Consultee Comments for Planning Application 1/1244/2022/FUL

Application Number: 1/1244/2022/FUL

Proposal: Replacement dwelling

On Behalf Of: Environmental Protection Officer

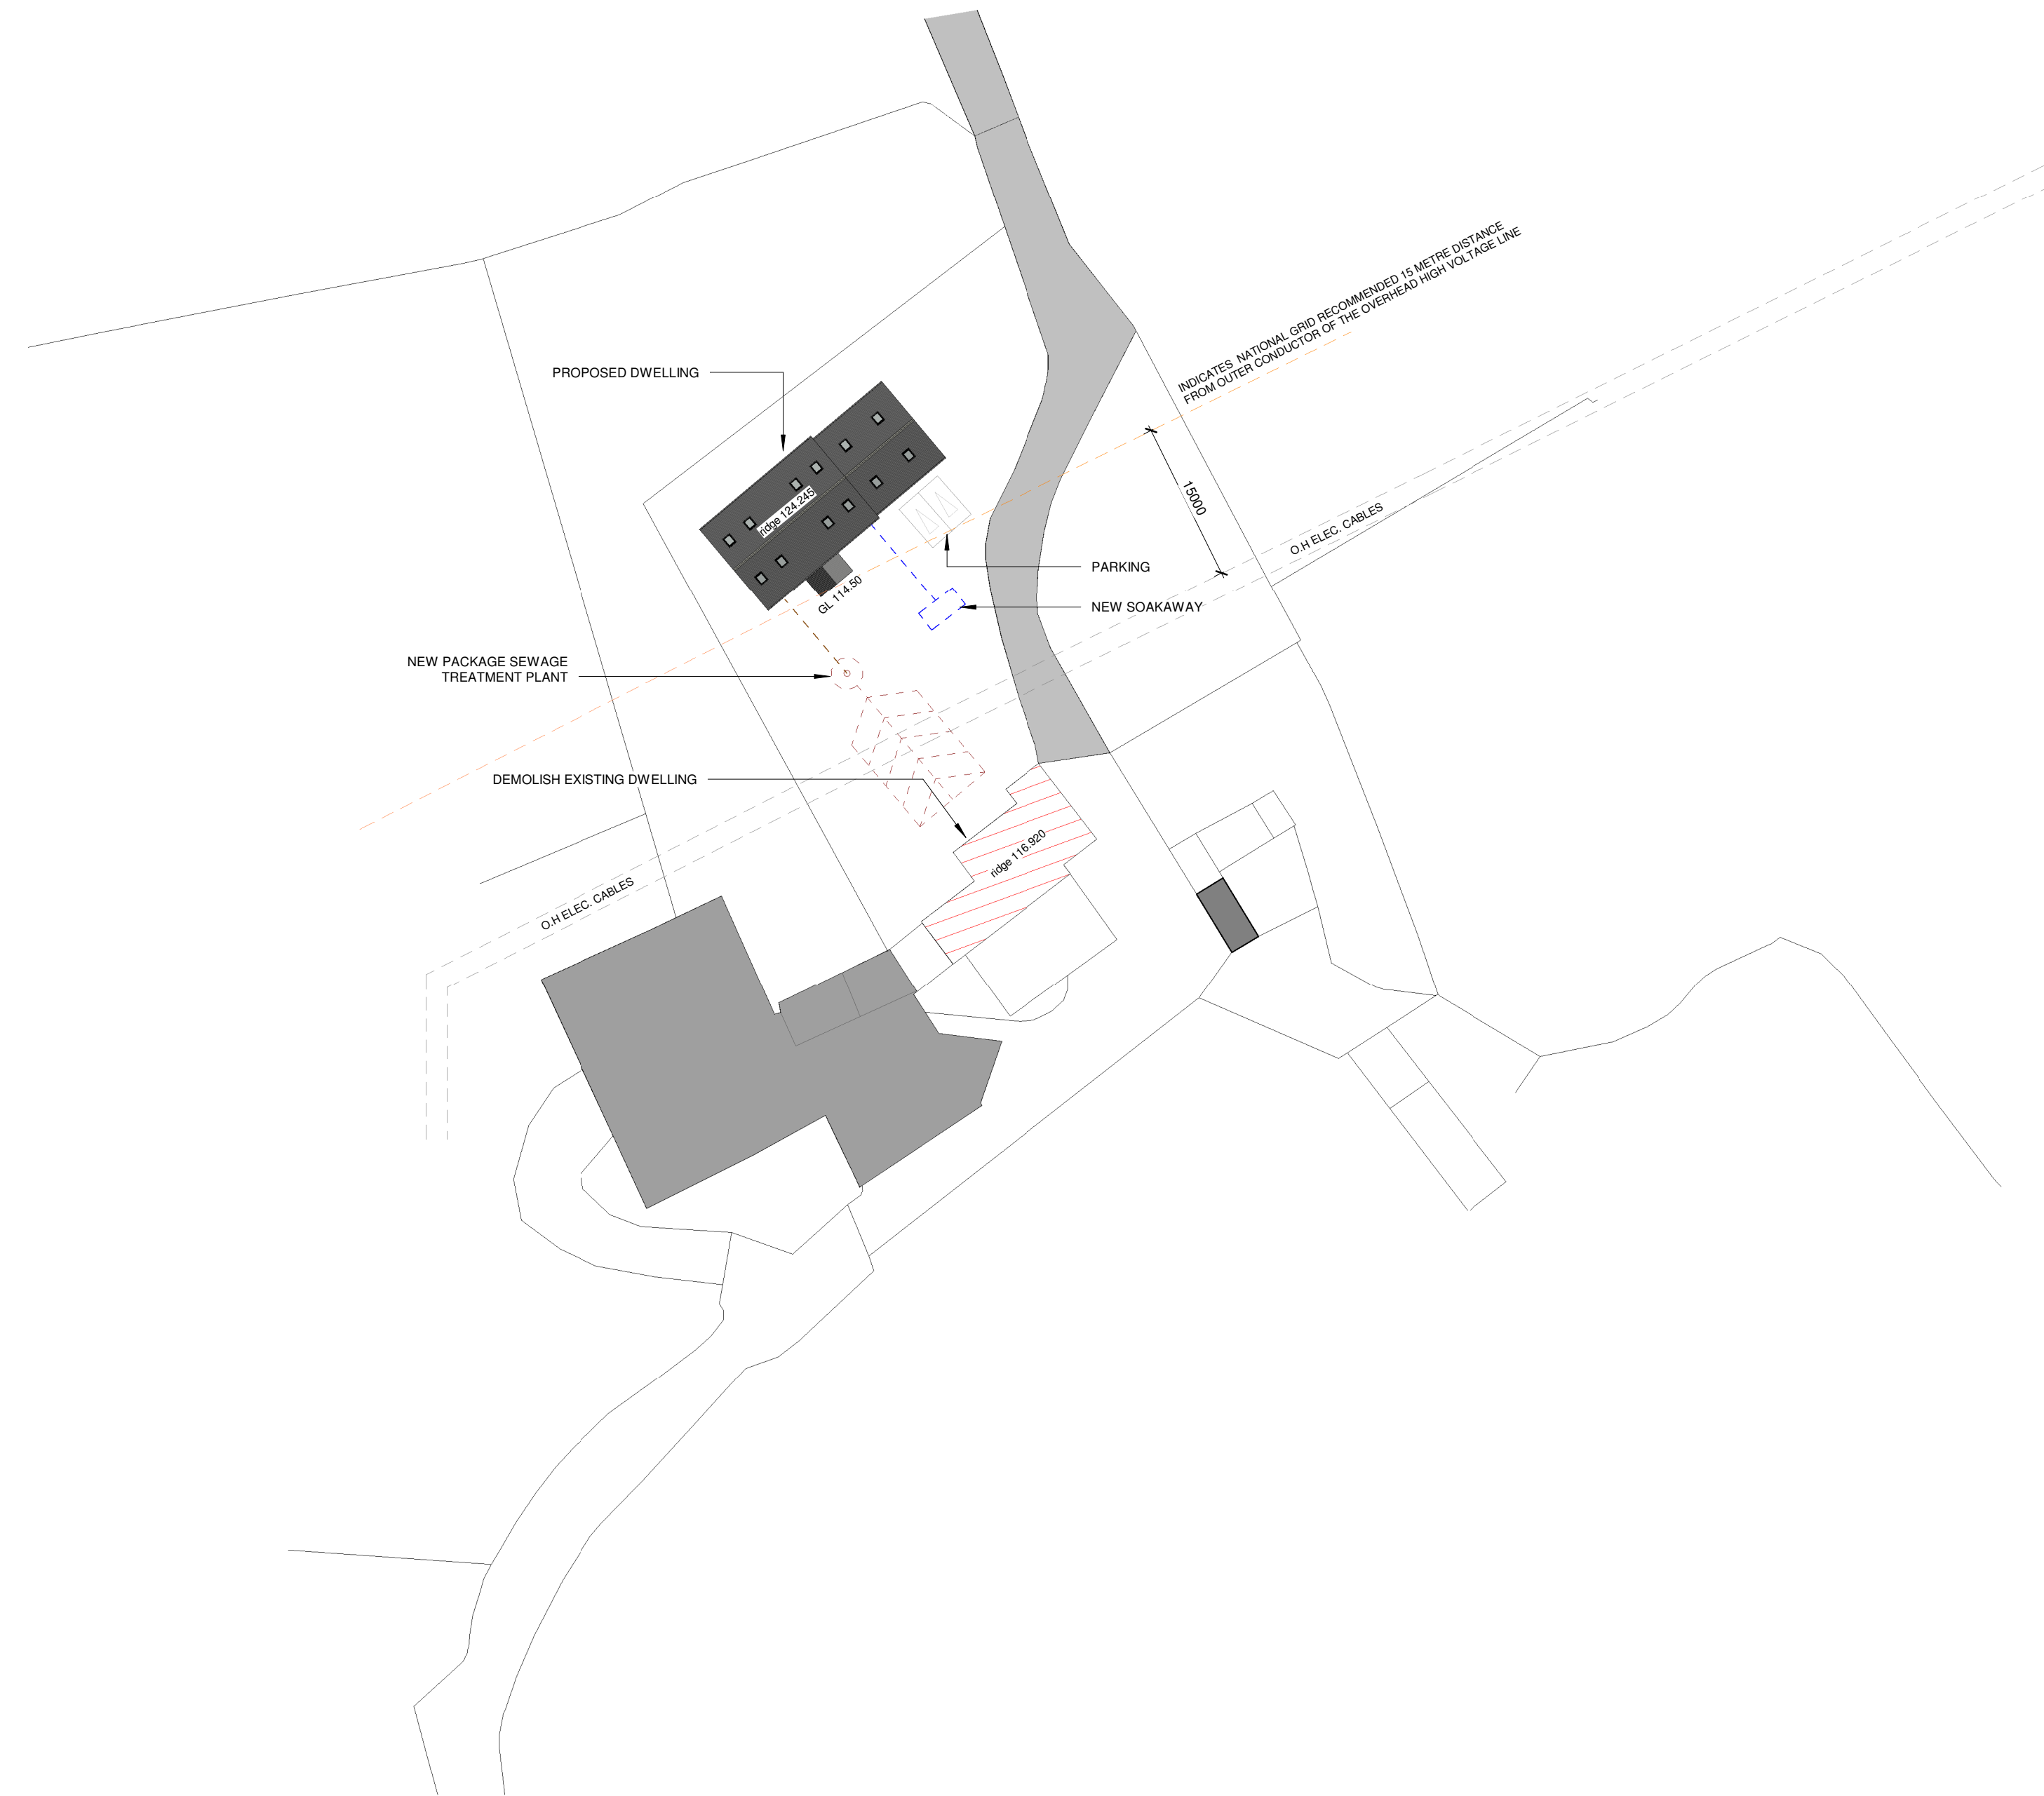
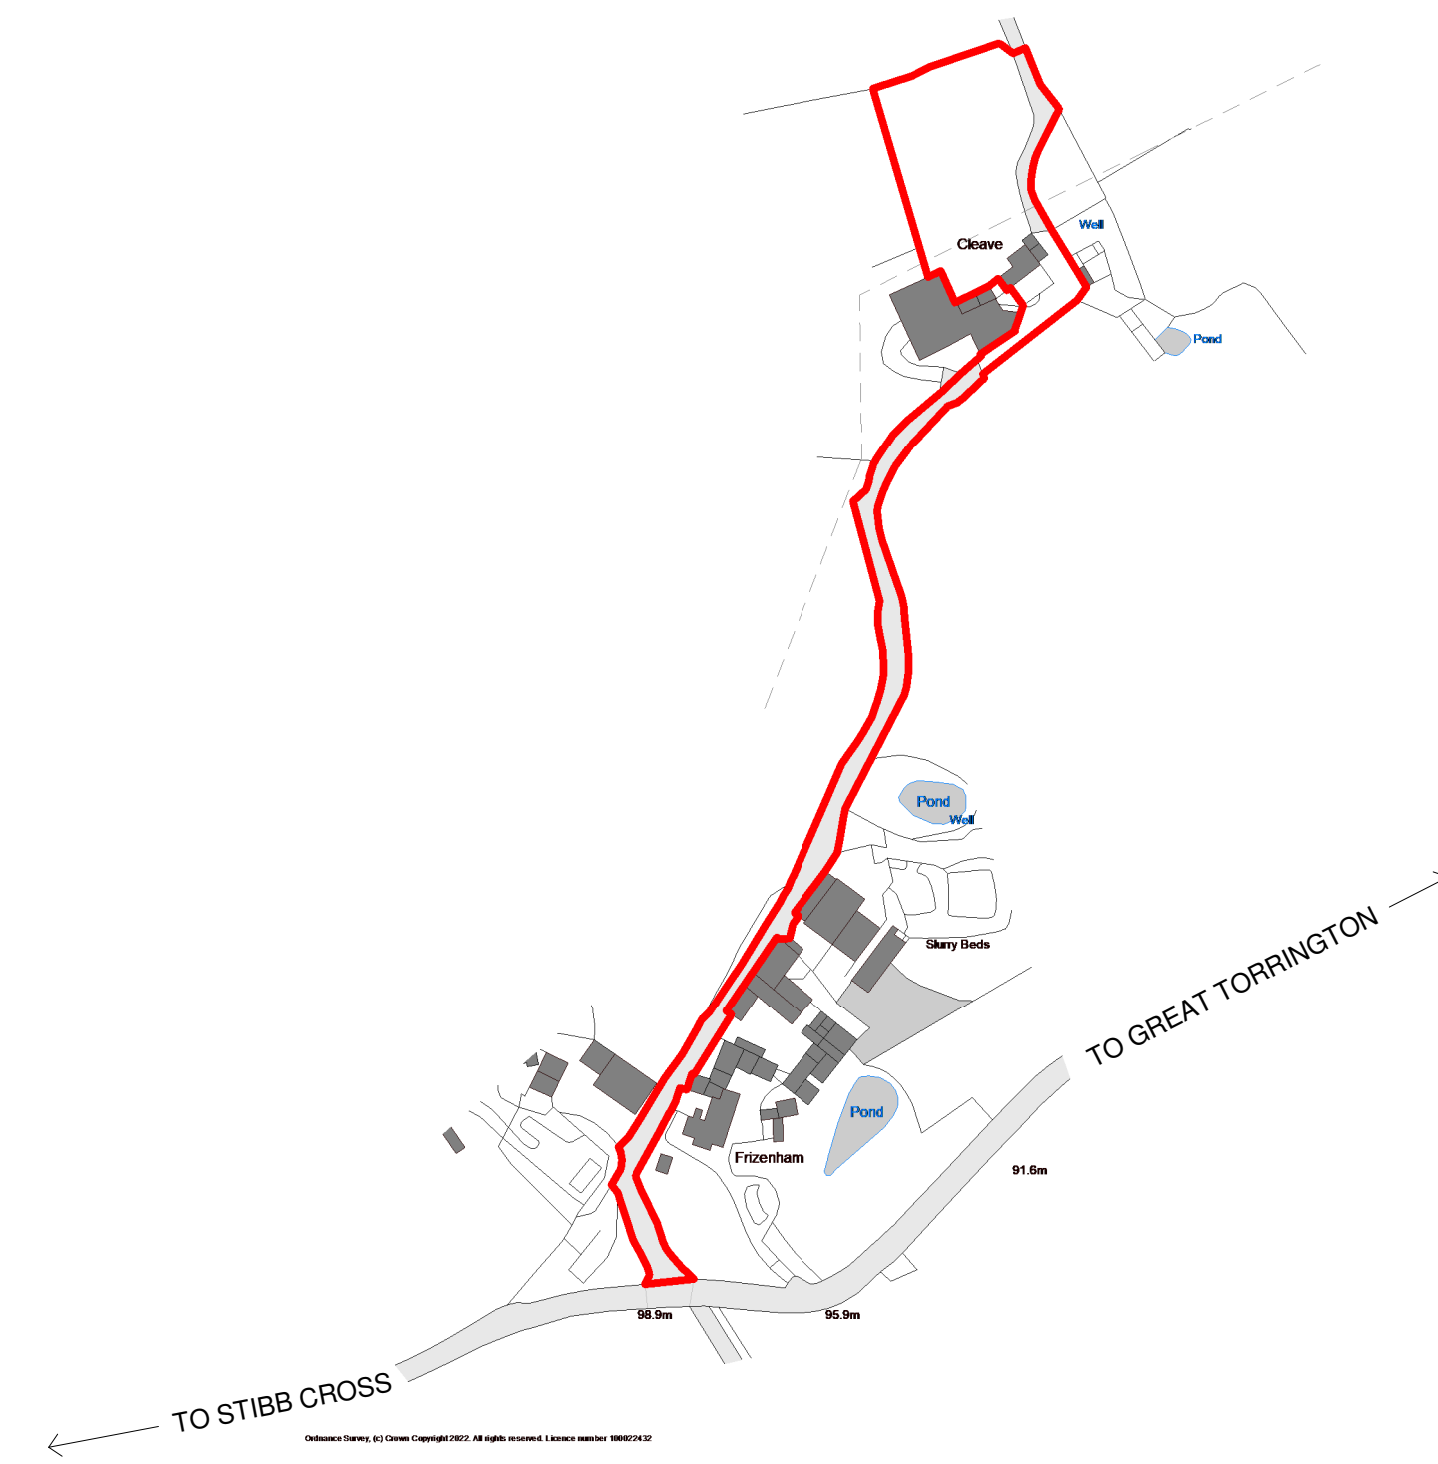
The Environmental Protection Team has no objections in principle to the proposed development. However, it is noted that a new sewage treatment plant is to be introduced that discharges to a drainage field. No percolation testing appears to have been undertaken making it difficult to assess whether the ground has suitable permeability to accommodate the proposed non-mains foul drainage scheme. The applicant will need to undertake percolation testing in accordance with BS6297 and submit the test results as well as the calculated drainage field area and location for review. The Environmental Protection Team will provide further comments upon receipt of the aforementioned information.
